Project Title: General Atomics (BP-2023-34420) Hydrology File # \_\_\_\_\_

City Address, UPC, OR Parcel: 14820 Central Avenue SE, Albuquerque, NM 87123

**Re: General Atomics Office  
14820 Central SE  
Traffic Circulation Layout  
Engineer's/Architect's Stamp 5-24-2024 (L23D011A)**

## TYPICAL BIKE RACK

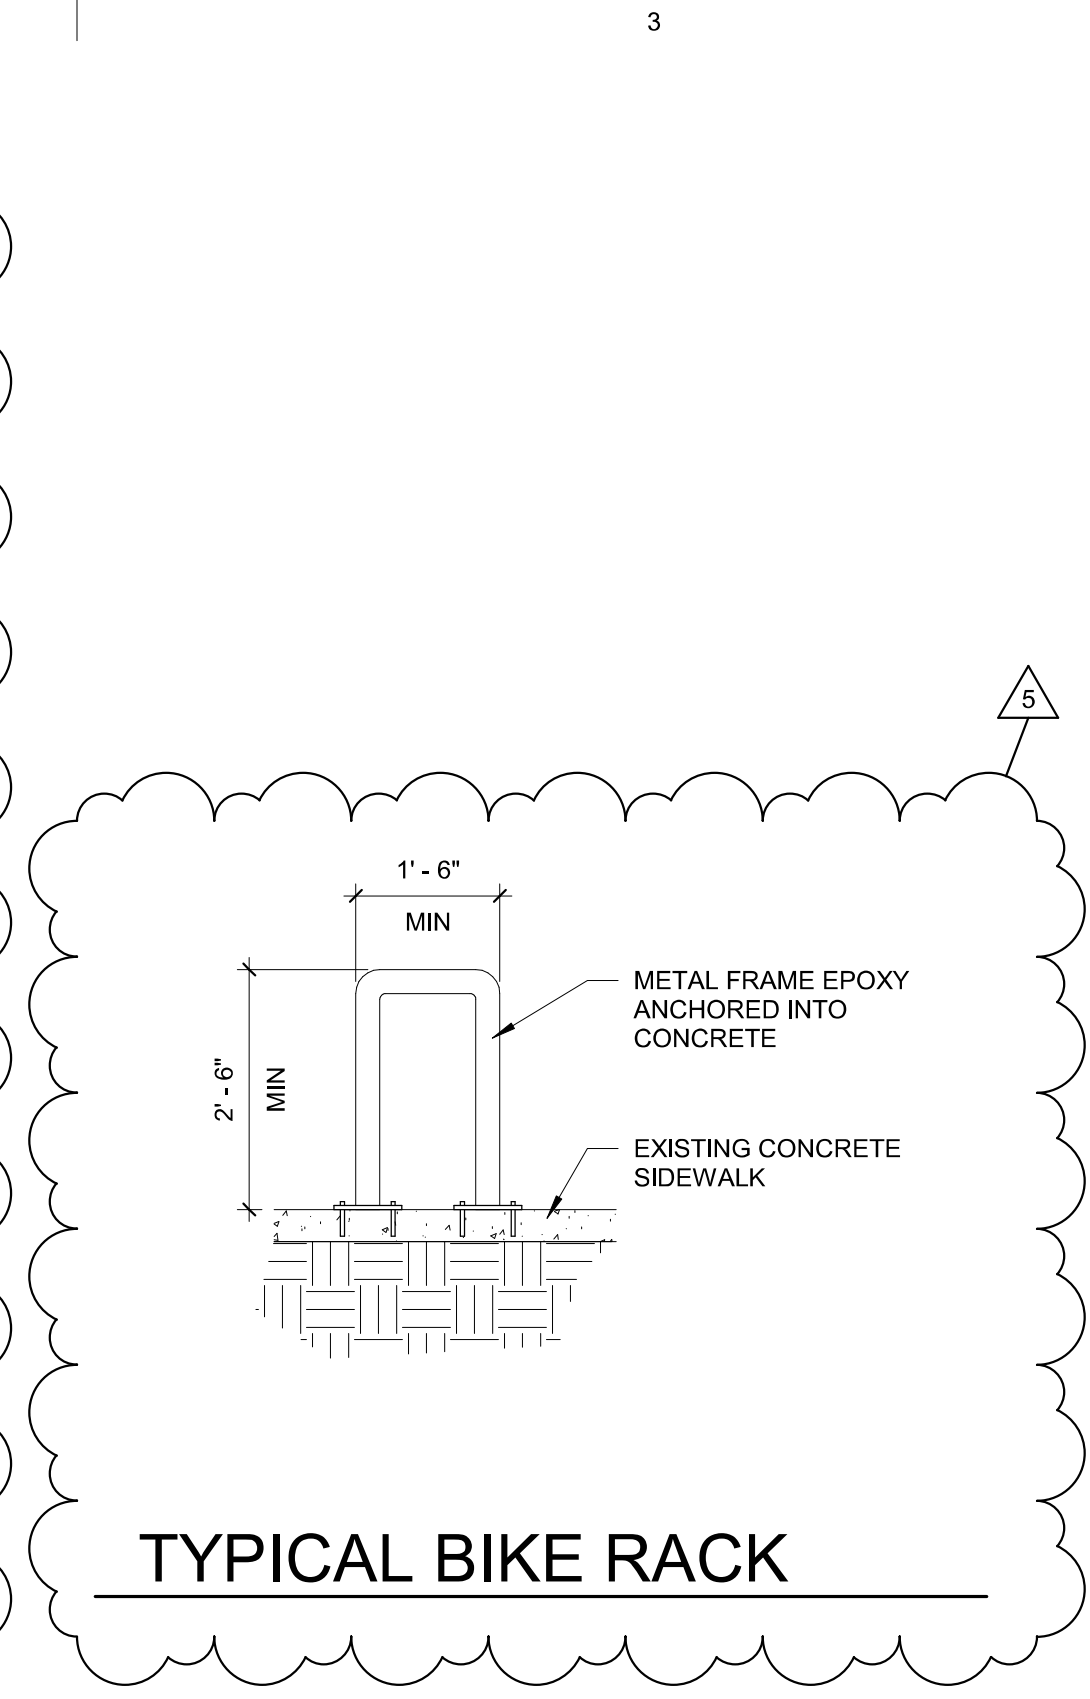
- a. The rack shall be a minimum 30 inches tall and 18 inches wide. Show your details.
  - b. The bicycle frame shall be supported horizontally at two or more places. Comb/toaster racks are not allowed.

9. All bicycle racks shall be designed according to the following guidelines: [Bike racks are shown on A3/AS101, and detail view is added to AS101.](#)

## A1 OVERALL SITE PLAN

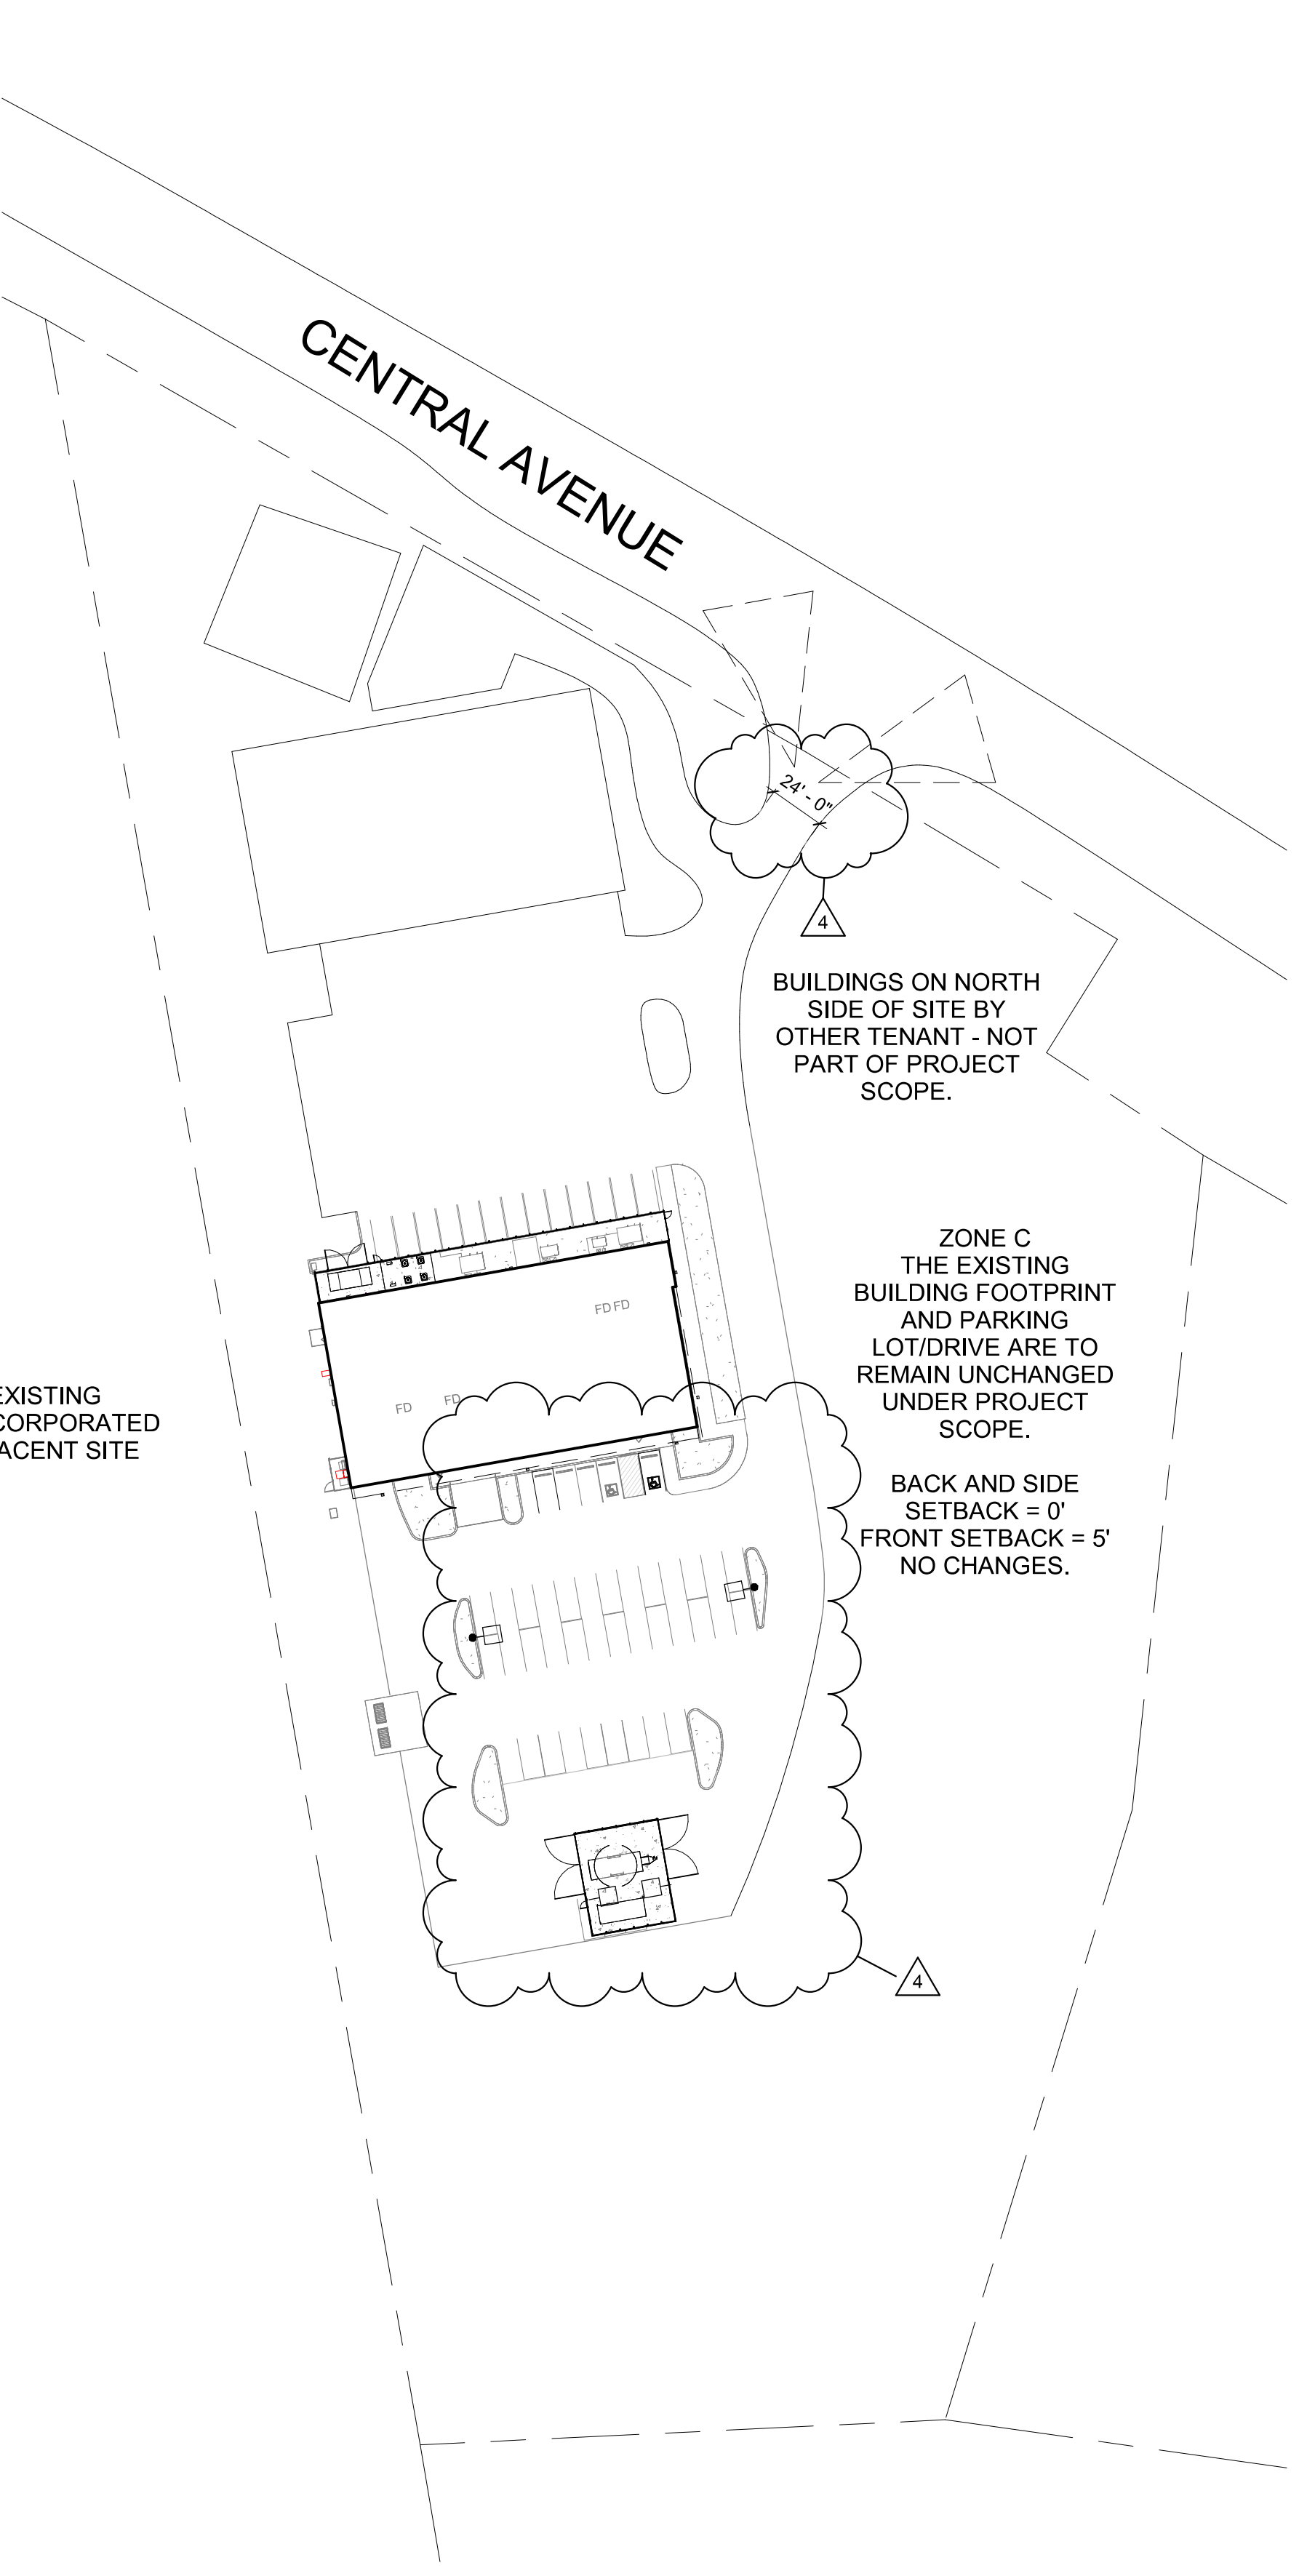
21. Show the clear sight triangle and add the following note to the plan: "Landscaping and signage will not interfere with clear sight requirements. Therefore, signs, walls, trees, and shrubbery between 3 and 8 feet tall (as measured from the gutter pan) will not be acceptable in the clear sight triangle. [Clear sight triangles are shown on A1/AS101, and Note F added under General Notes.](#)

## A3 SITE PLAN

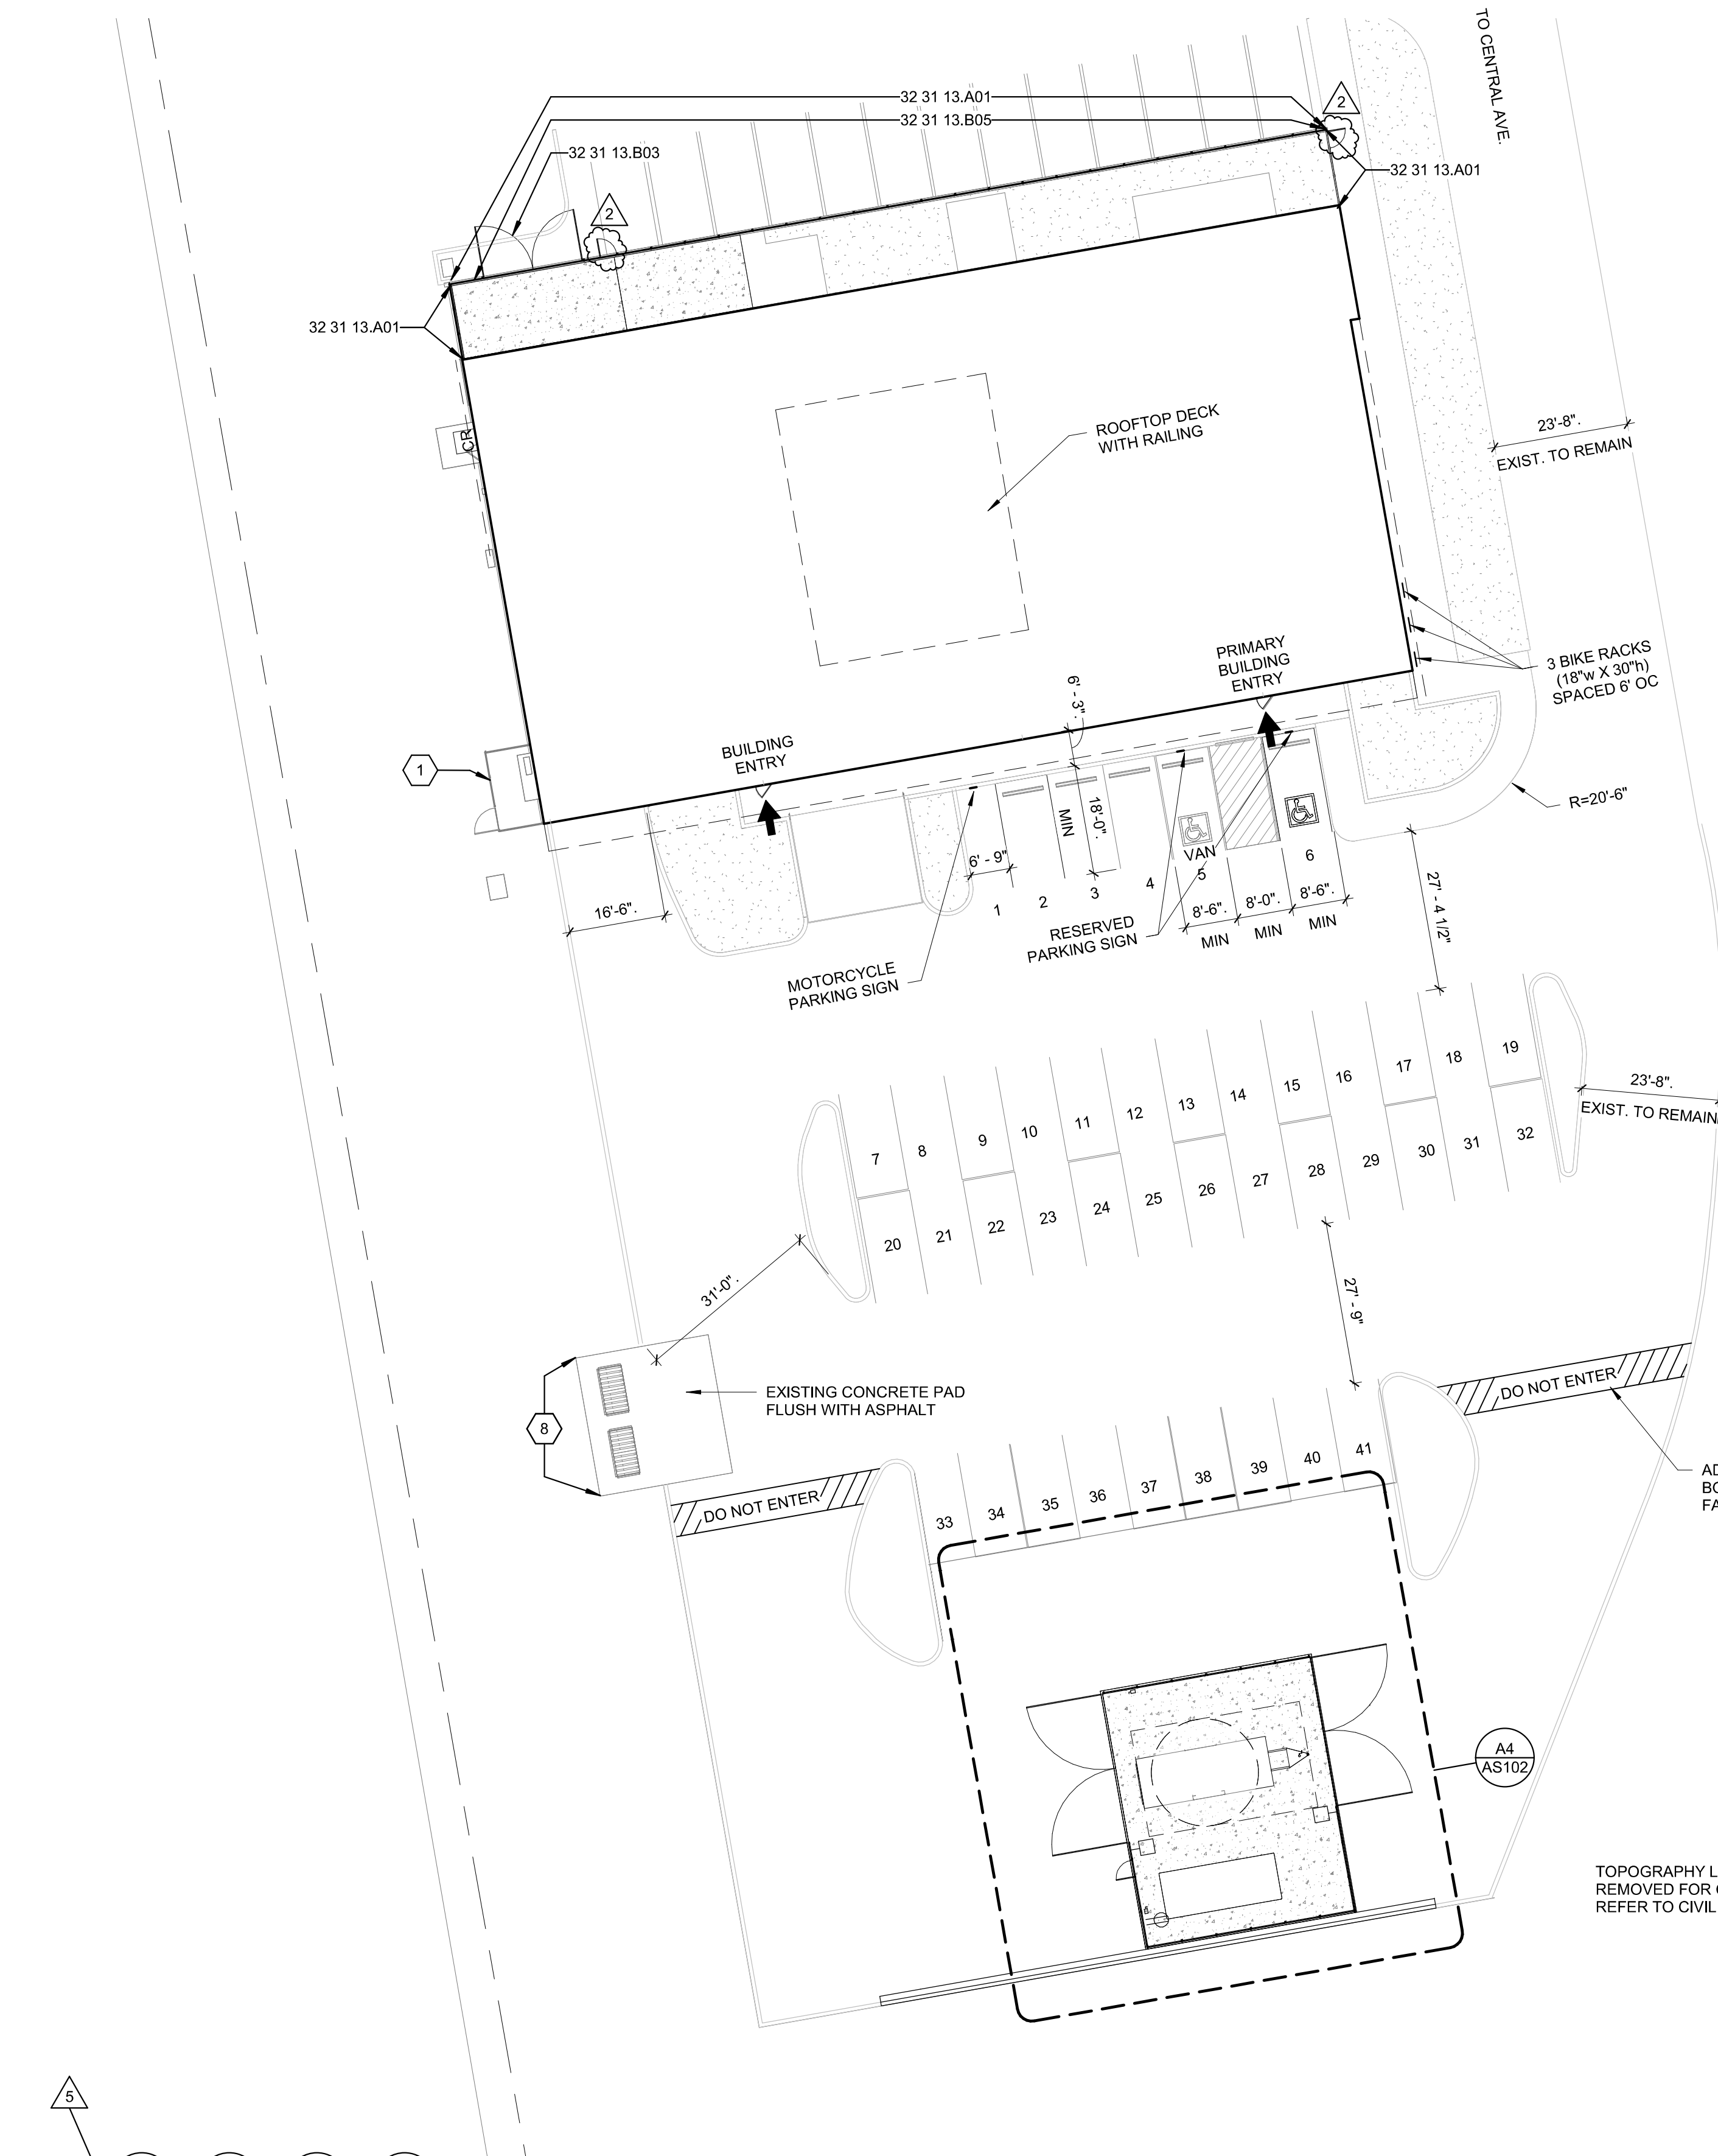
- Please show a vicinity map on sheet AS101 showing the location of the development in relation to streets and well known landmarks.  
*Please see attached, vicinity map is shown on G-001.*
- In the parking list indicate that one of the two ADA spaces should be for van.  
*Van space is shown graphically on A3/AS101.*
- All accessways to the site from the adjacent roadway shall be ADA-compliant.  
*An accessible path is provided from HC parking spaces to the building.*
- Please list the width and length for all existing and proposed parking spaces. Some dimensions are not shown.  
*Added dimensions are shown on A3/AS101.*
- The minimum parking stall dimensions are:

6. The ADA accessible spaces must include an access aisle. Van accessible aisles should be 8ft wide; all others should be 5ft wide.

8. Motorcycle parking spaces shall be designated by its own conspicuously posted upright sign, either free-standing or wall mounted per the zoning code. [Location of the motorcycle sign is shown on A3/AS101.](#)

- c. The rack allows varying bicycle frame sizes and styles to be attached.
10. Bicycle racks shall be sturdy and anchored to a concrete pad. [See response to item #9.](#)

11. A 1-foot clear zone around the bicycle parking stall shall be provided. [See response to item #9.](#)

12. Bicycle parking spaces shall be at least 6 feet long and 2 feet wide.

13. Show all drive aisle widths and radii. Some dimensions are not shown.

14. The minimum drive aisle dimensions are shown below [See response to item #13.](#)

15. List radii for all curves shown; for passenger vehicles. Radius for delivery trucks, fire trucks, etc. is 25 ft. or larger. [See response to item #13.](#)
16. Per the DPM, a 6 ft. wide ADA accessible pedestrian pathway is required from the public sidewalk to the building entrances. Please clearly show this pathway and provide details. [The existing pedestrian pathway is 6'-3" wide.](#)
17. Per DPM, a 6 ft. wide ADA accessible pedestrian pathway is required from the ADA parking stall access aisles to the building entrances. Please clearly show this pathway and provide details. [Please see A3/AS101. Relocated HC spots are approximately 10' from the primary entrance to the building.](#)

Dimensions revised per our discussion are shown on A3/AS101.

Dimensions revised per our discussion are shown on A3/AS101. The owner's intent is to keep the existing access to the site as is. Approximate dimensions of the existing layout with the main access at 24'-0" and various other aisles ranging from 23'-8" to 30'-0"+ are shown on A3/AS101.
